May 4, 2018

RE: Letter of Intent – Liberty Tree Academy

Site Address: 8579 Eastonville Road

1 PROPOSED SITE PLAN
SP1.0 1" = 30'-0"

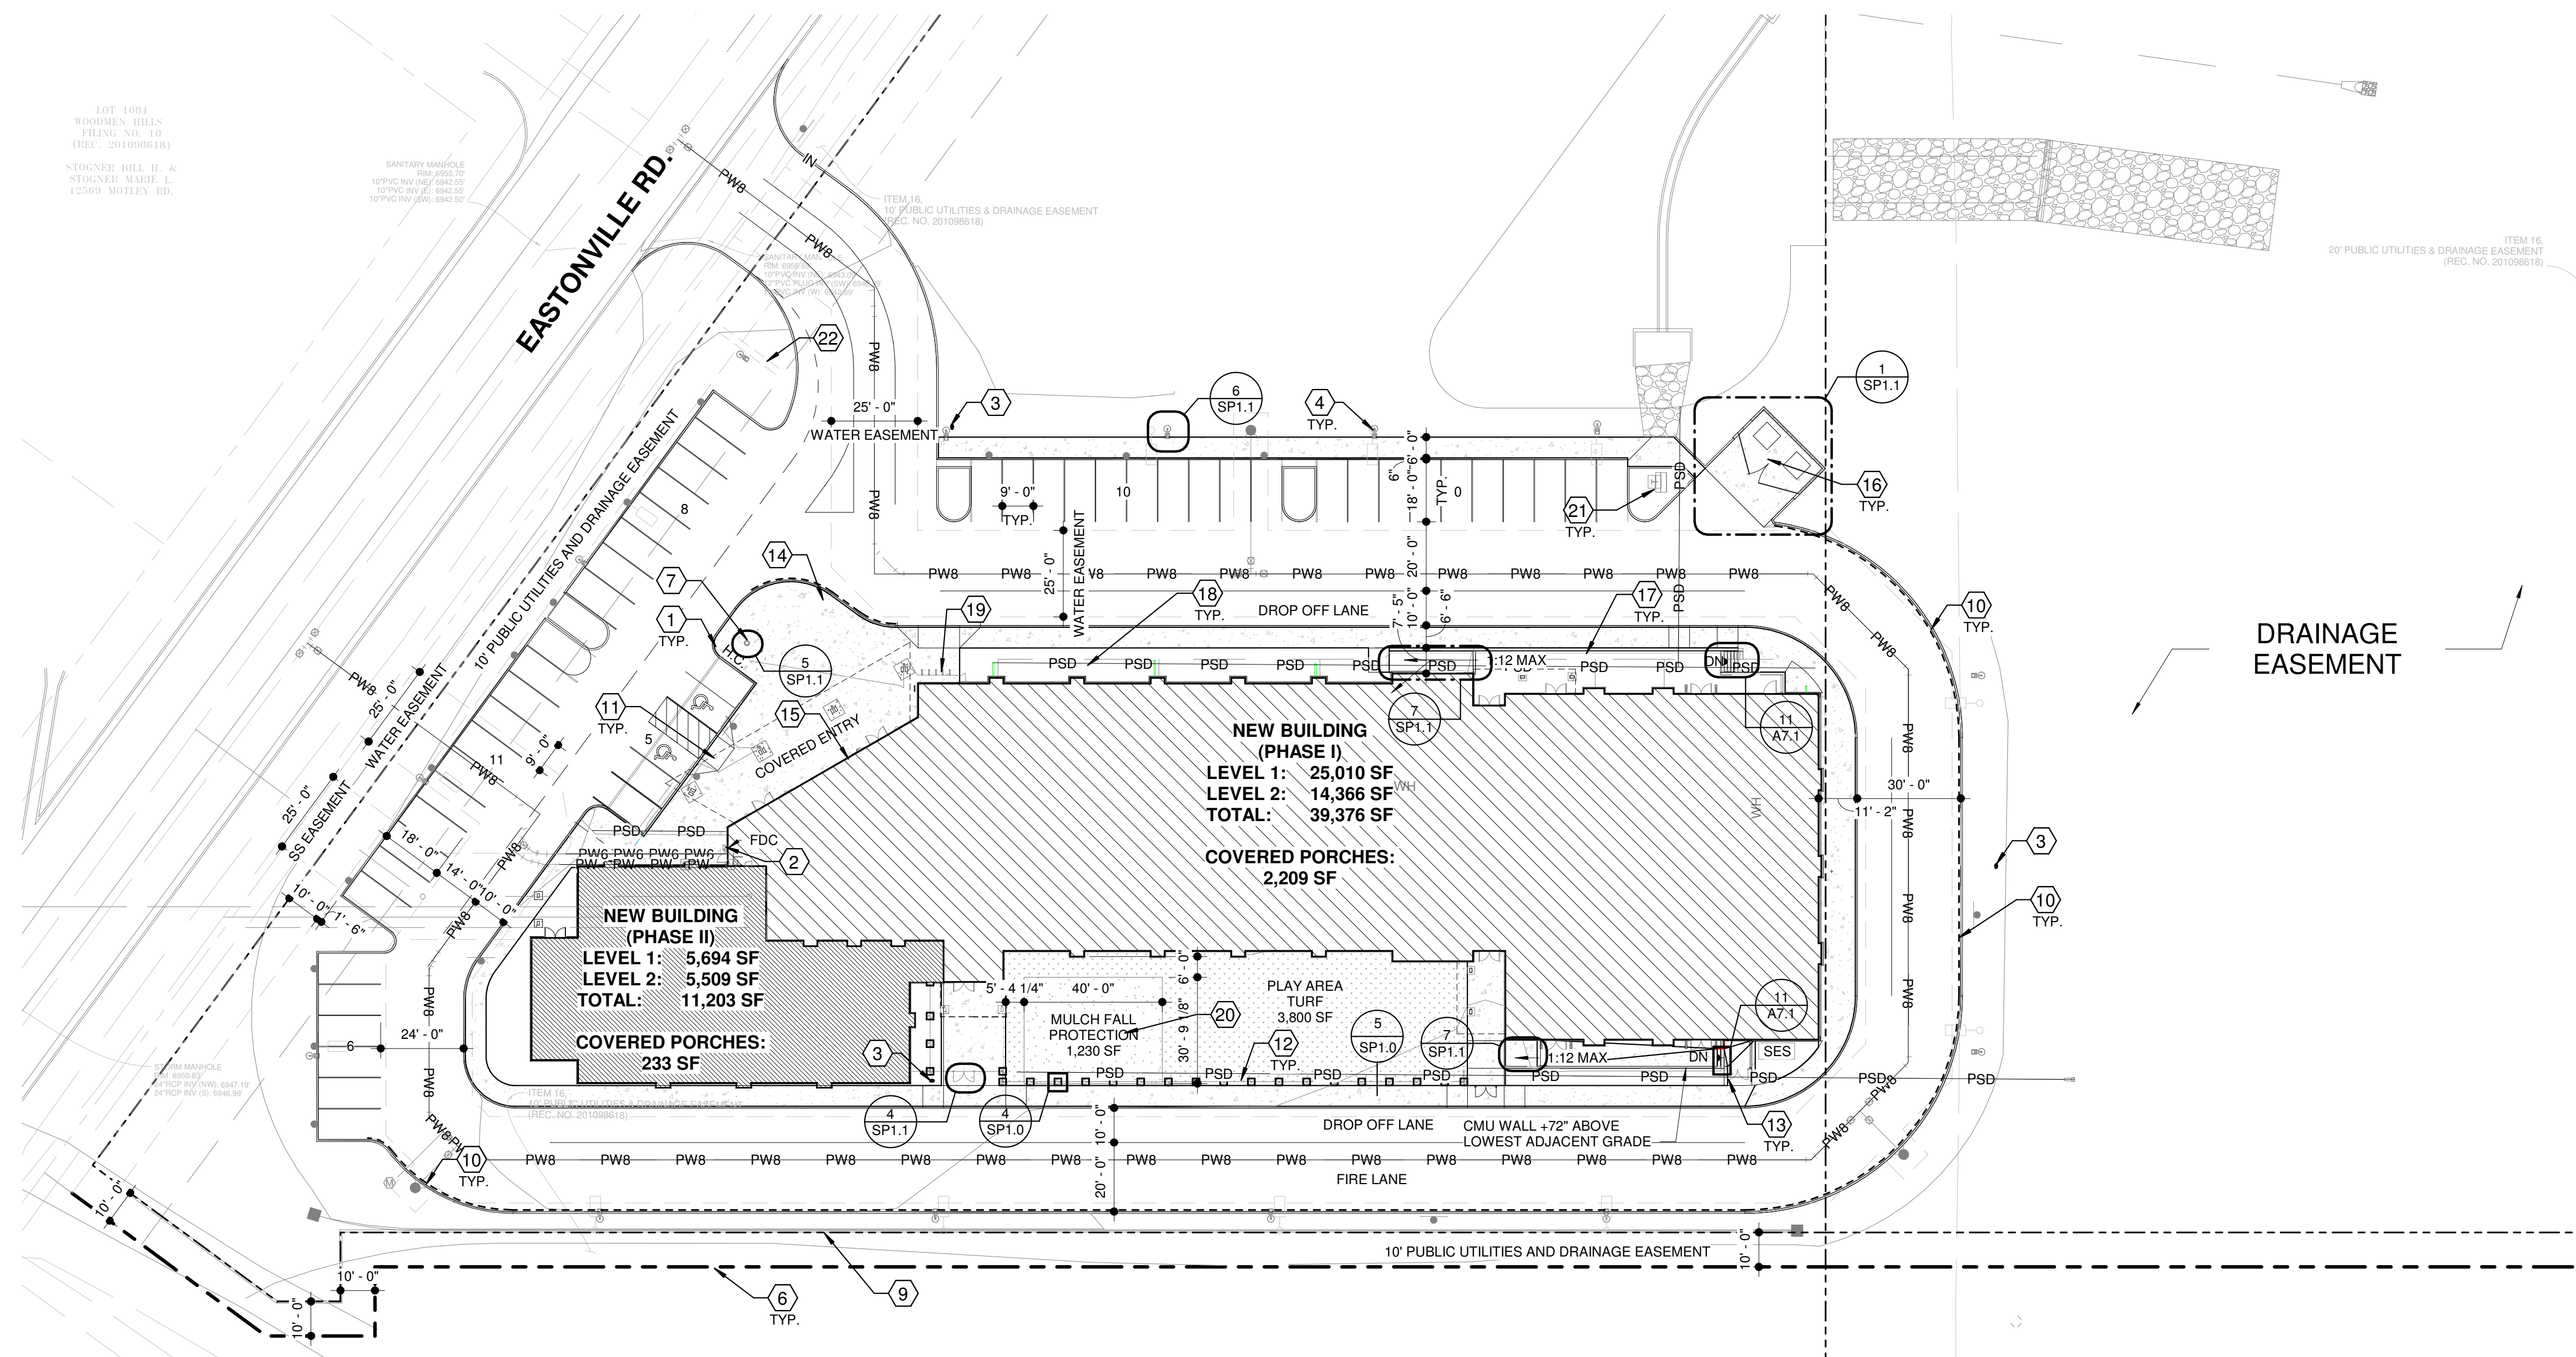
Site Development Plan shows different. - 44 spots are required plus an additional 2 disabled spots.
